### Amendment in accordance with s96 (1A) to SSD 6107 Parkes Hospital

In July this year the Department of Planning and Environment issued approval for the Parkes Hospital development. Since that time a number of minor amendments have become necessary to address changes to the detailed design. The proposed amendments are described below and shown on the attached drawings.

1 PLAN
SITE PLAN

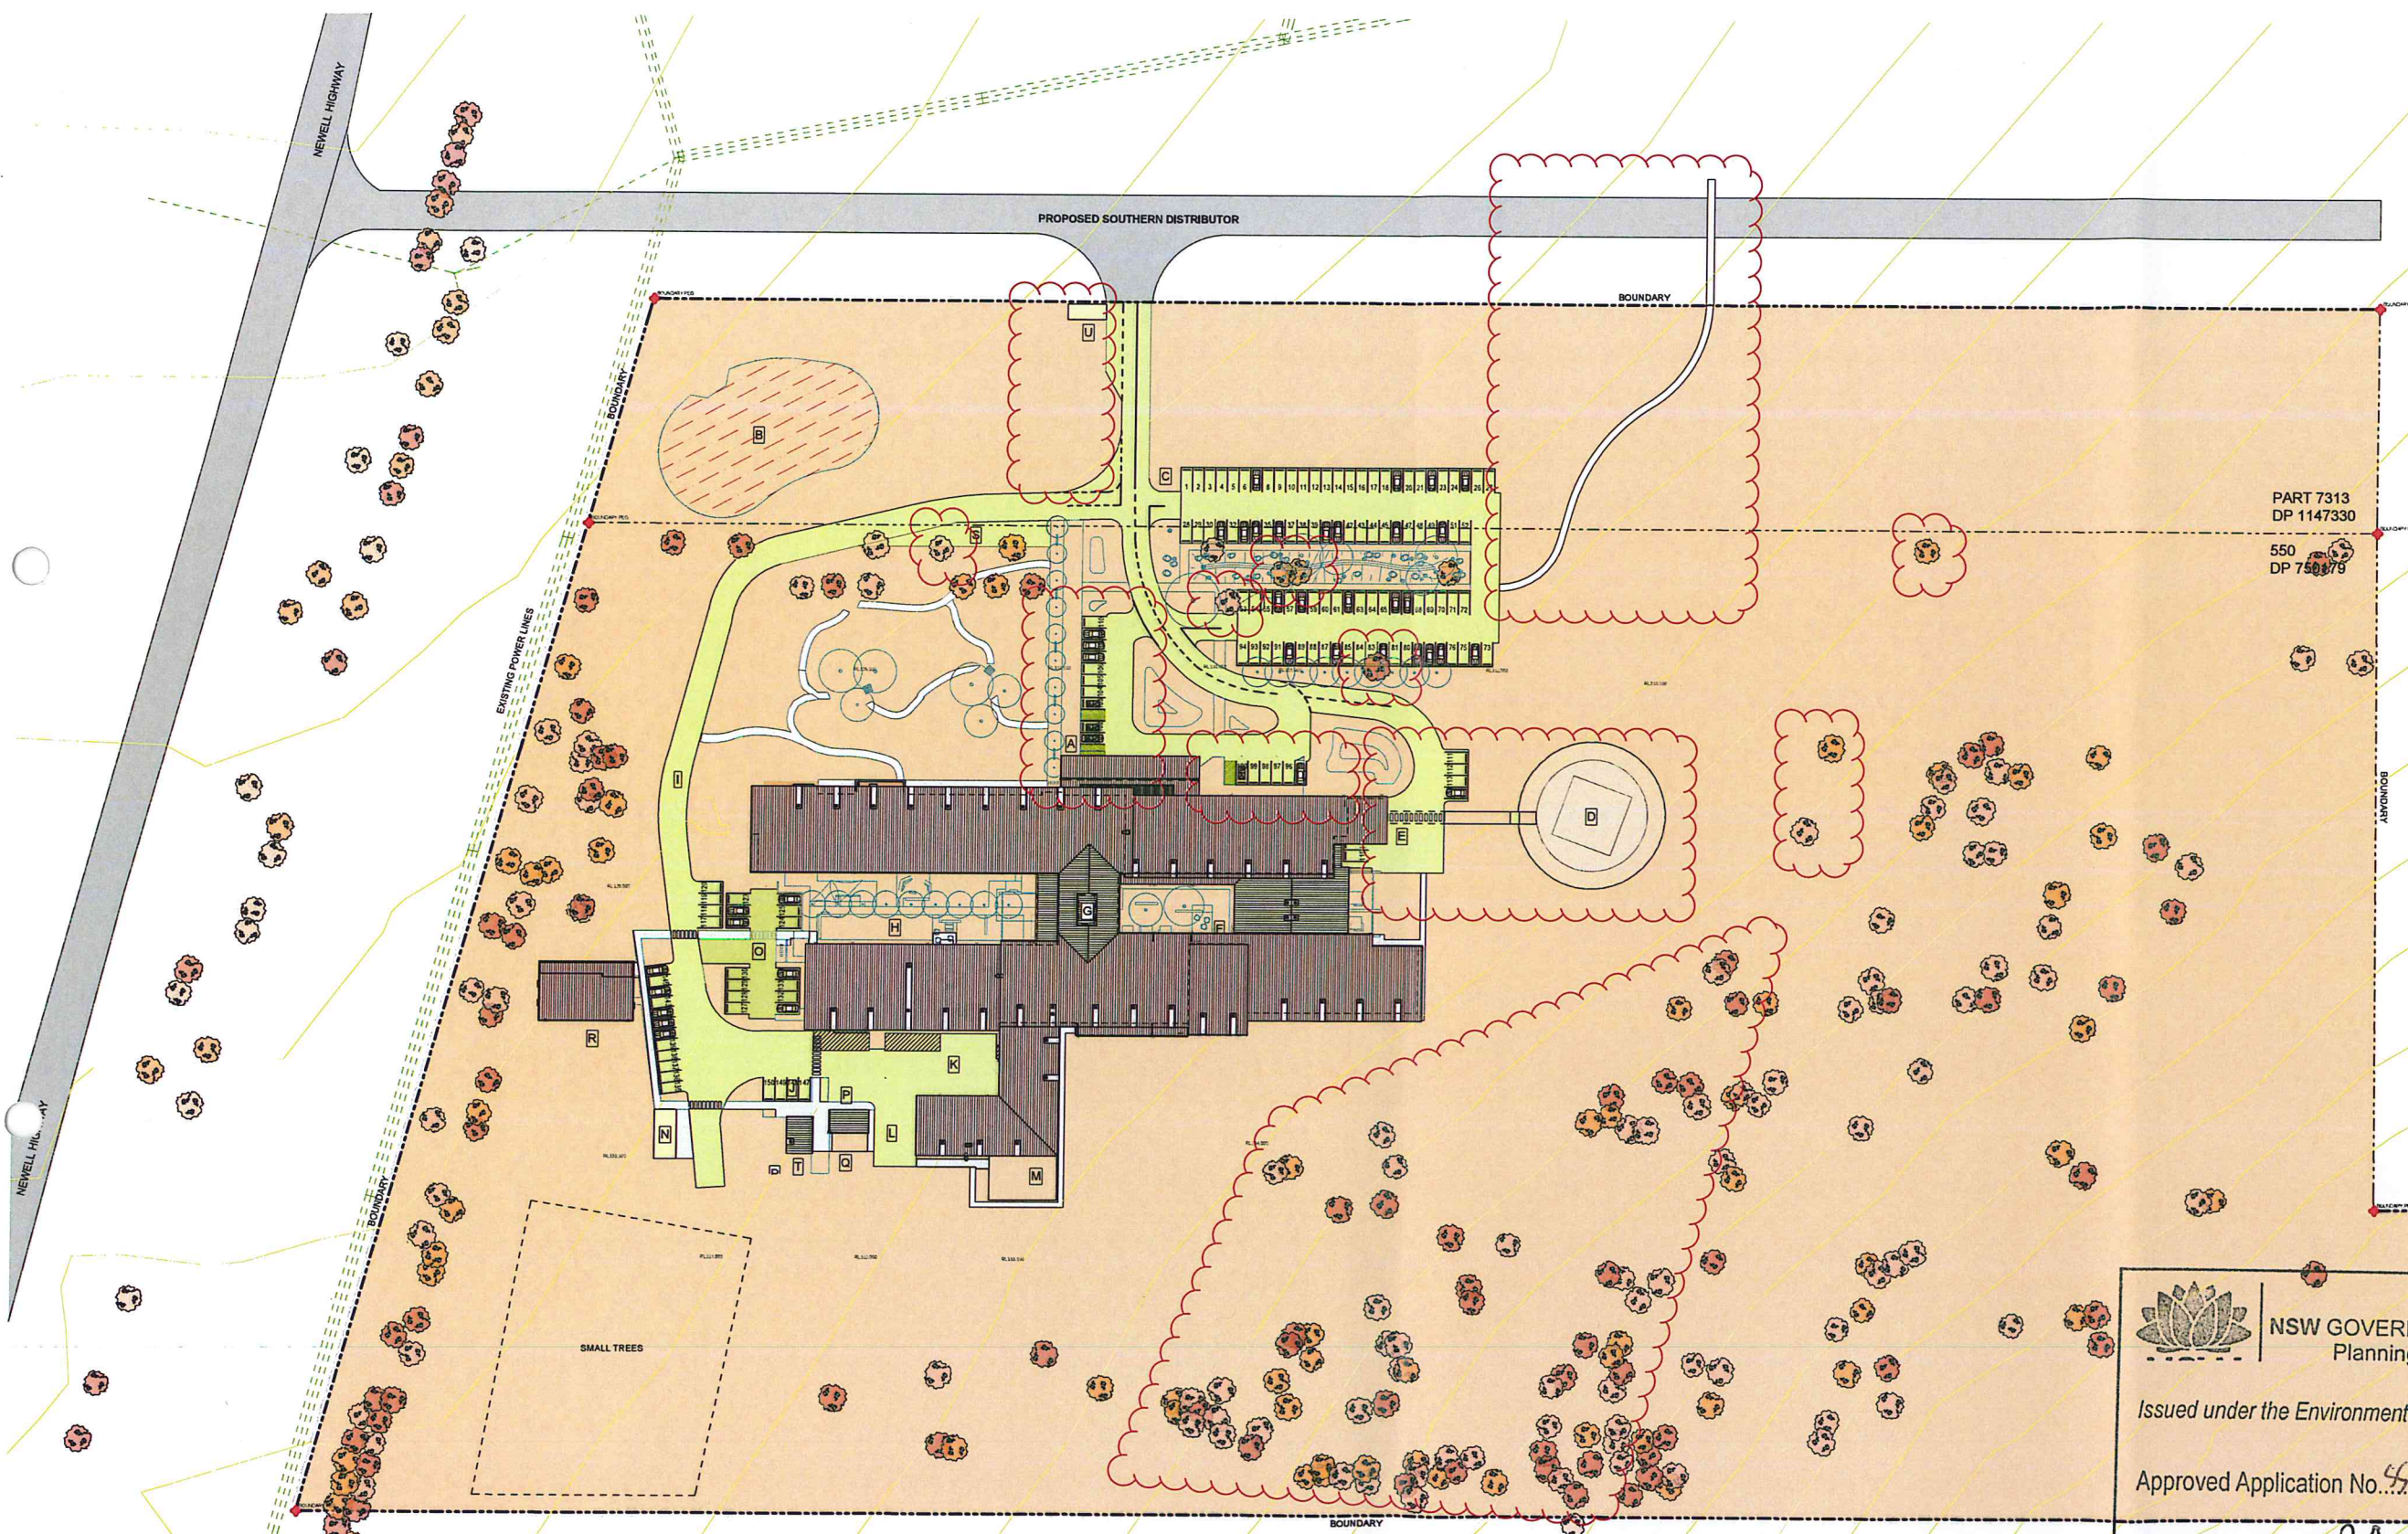
The removal of additional trees is required for construction of road and car parking pavements. The following trees to be removed are on Drawing 4828-RD-AR-DWG-PM-0600 issue 6 attached. There are five (5) trees to be removed in total and are described in the table below.

Tree #	Bot. Name	Common Name	Reason	Condition
191	Eucalyptus melliodora	Yellowbox	Located within the proposed carpark	Severe Dieback
200	Eucalyptus melliodora	Yellowbox	Located within work zone for roadway	Multistem inclusions
201	Eucalyptus melliodora	Yellowbox	Located within work zone for roadway	Occluded bark
288	Eucalyptus melliodora	Yellowbox	Located within the proposed carpark	Attacked by Borer
NA	Pinus sp		Located within the proposed carpark	Not known

In addition to these trees, a group of approximately 50 trees, identified as being primarily White Cypress Pine in the attached arborists report are required to be removed to accommodate the helicopter flight path. The aviation consultants – Lambert & Rehbein – have advised:

1 PLAN
GROUND FLOOR
1:250

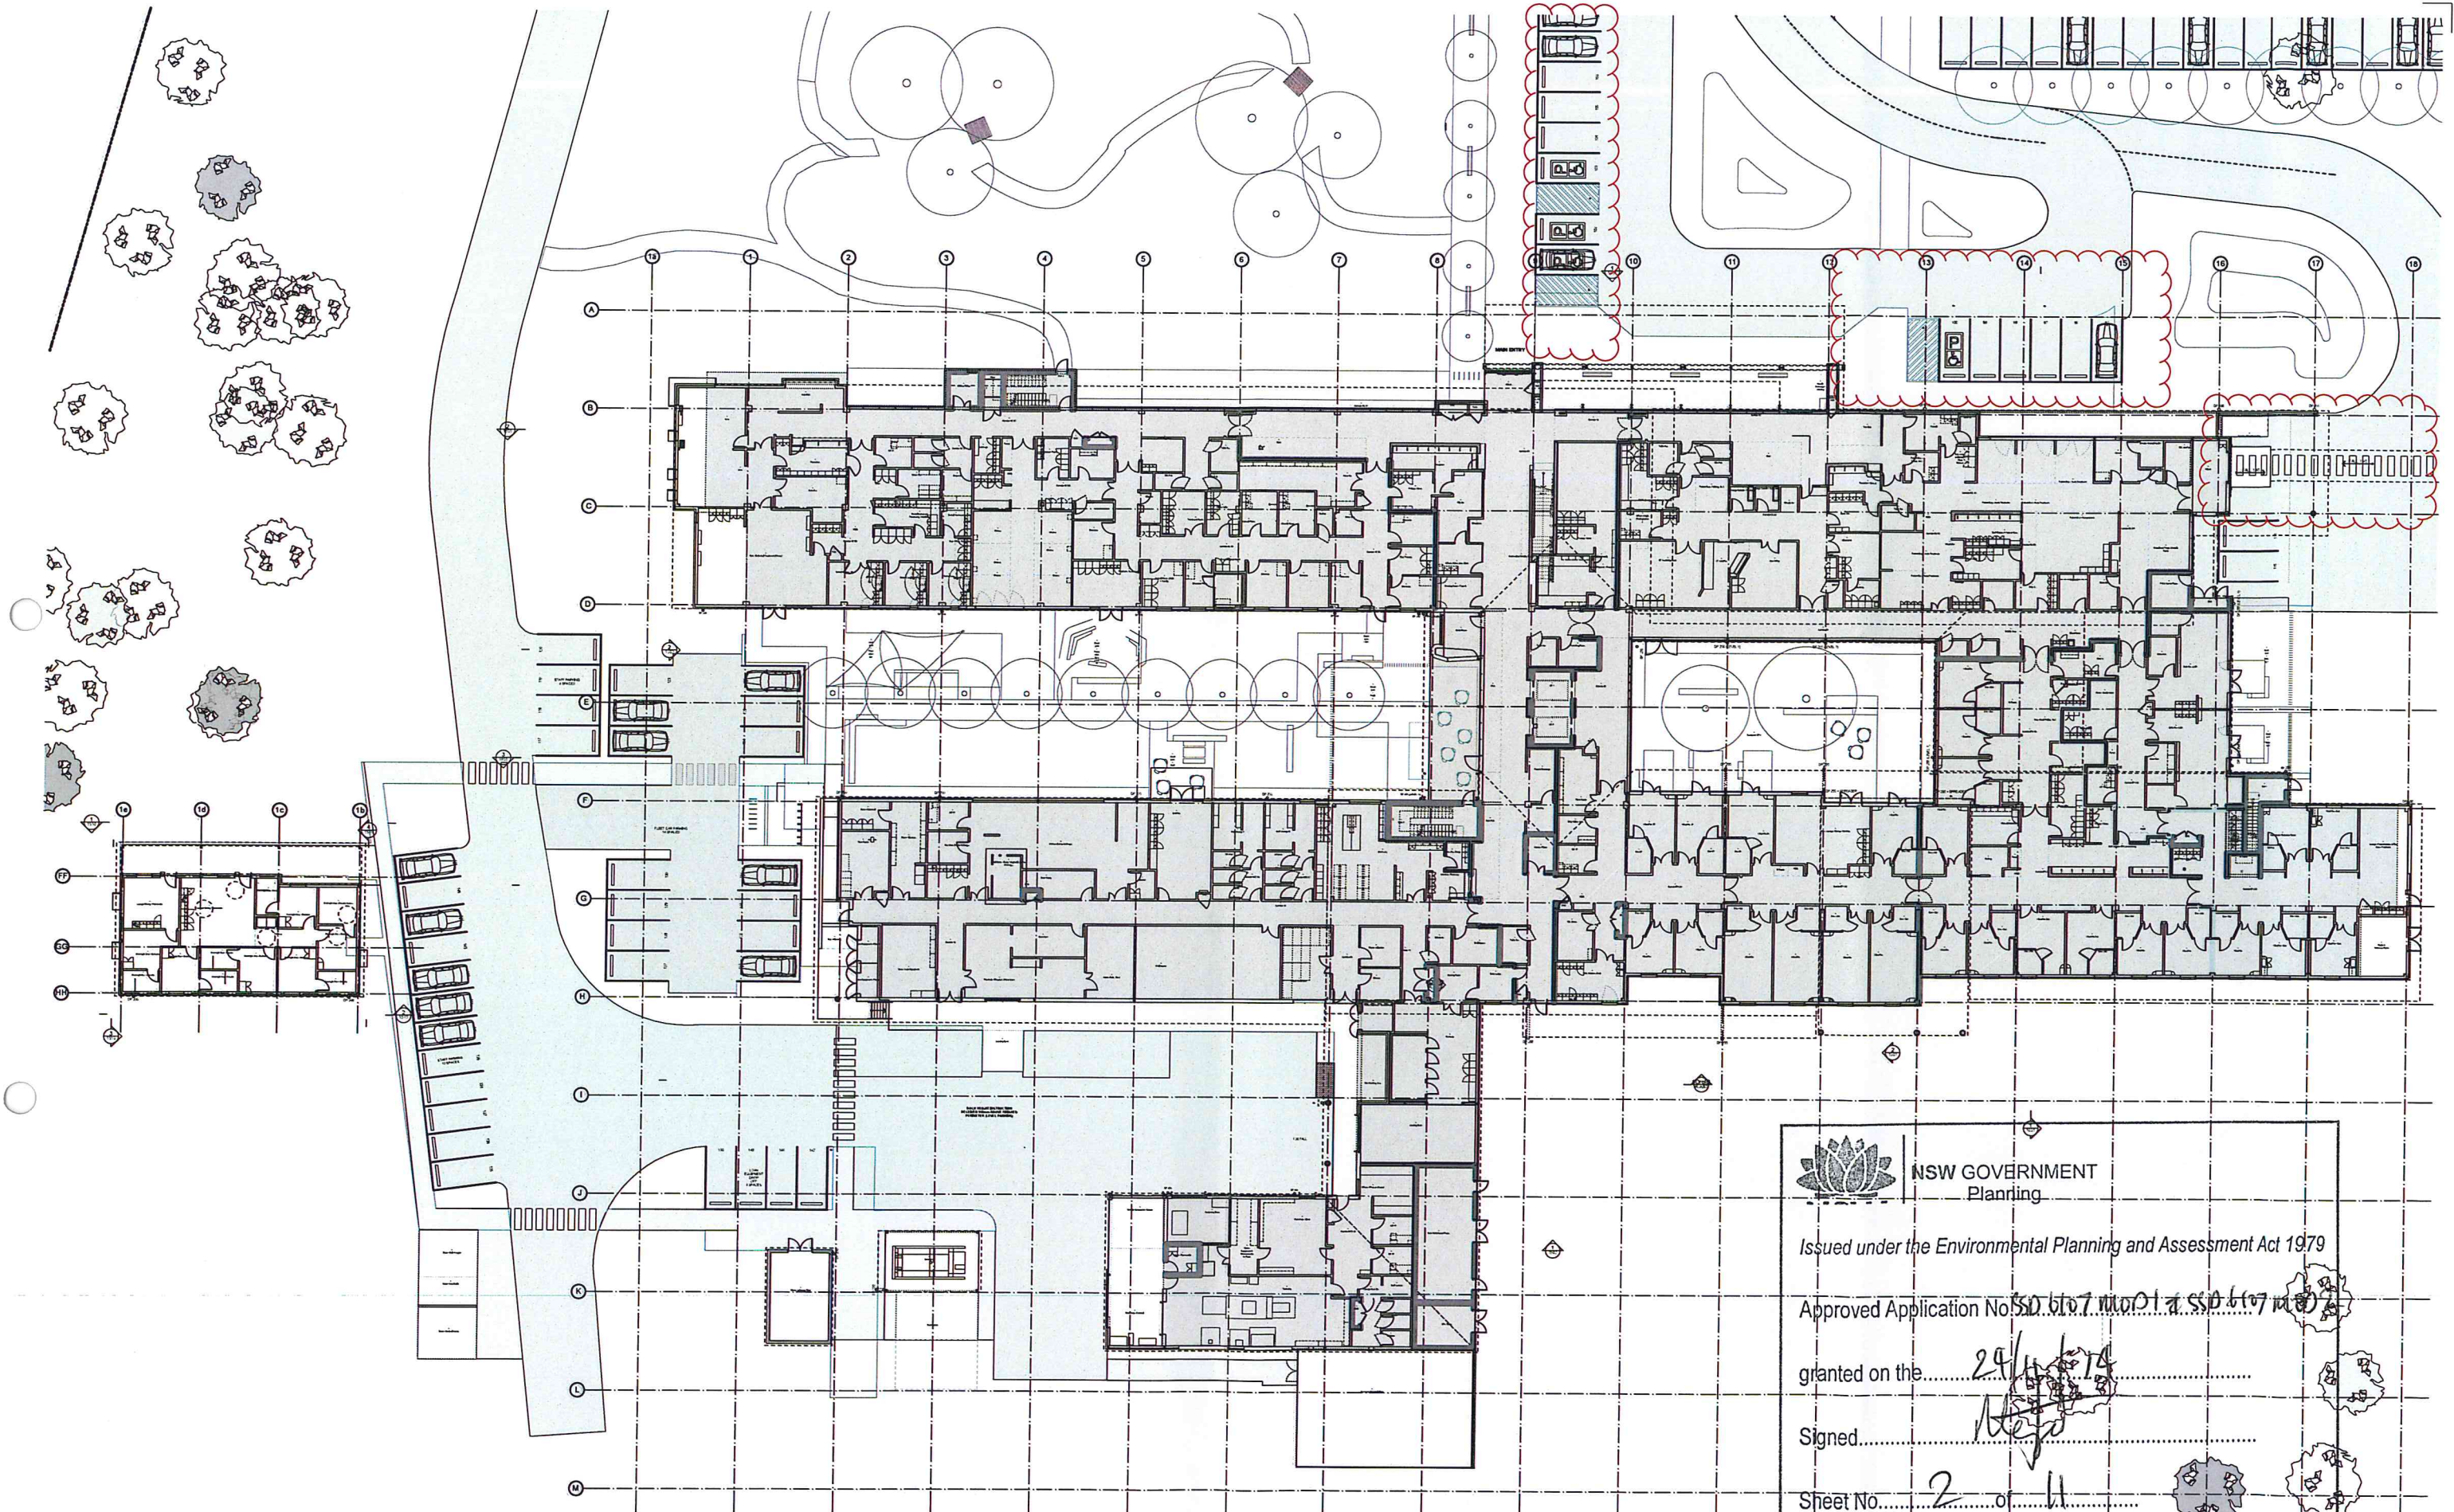
Additional parking spaces have been added near the entrance to the Hospital to address user concerns with the previous carpark configuration. The spaces, which are designated for use by disabled persons and persons with limited mobility have been located near the entrance to limit the travel distance between the carpark and the entrance to the Hospital. The current approved design incorporates 143 parking spaces and the proposed amendment will involve an additional 7 bring the total car park numbers to 150.

Parkes Shire Council is constructing a cycleway and pedestrian link from the site to the town centre. Council's path will cross the proposed southern distributor approximately 130m west of the Hospital access road to avoid merging lanes to the intersection of the southern distributor and hospital access road, and southern distributor and Newell Highway. The proposed pedestrian link and cycleway has been relocated to coordinate with the location of Council's cycleway.

The access to the helipad has been reconfigured to simplify access between the Emergency Department, Ambulance Bay and the Helipad. This was done as a result of requirements of Ambulance NSW.
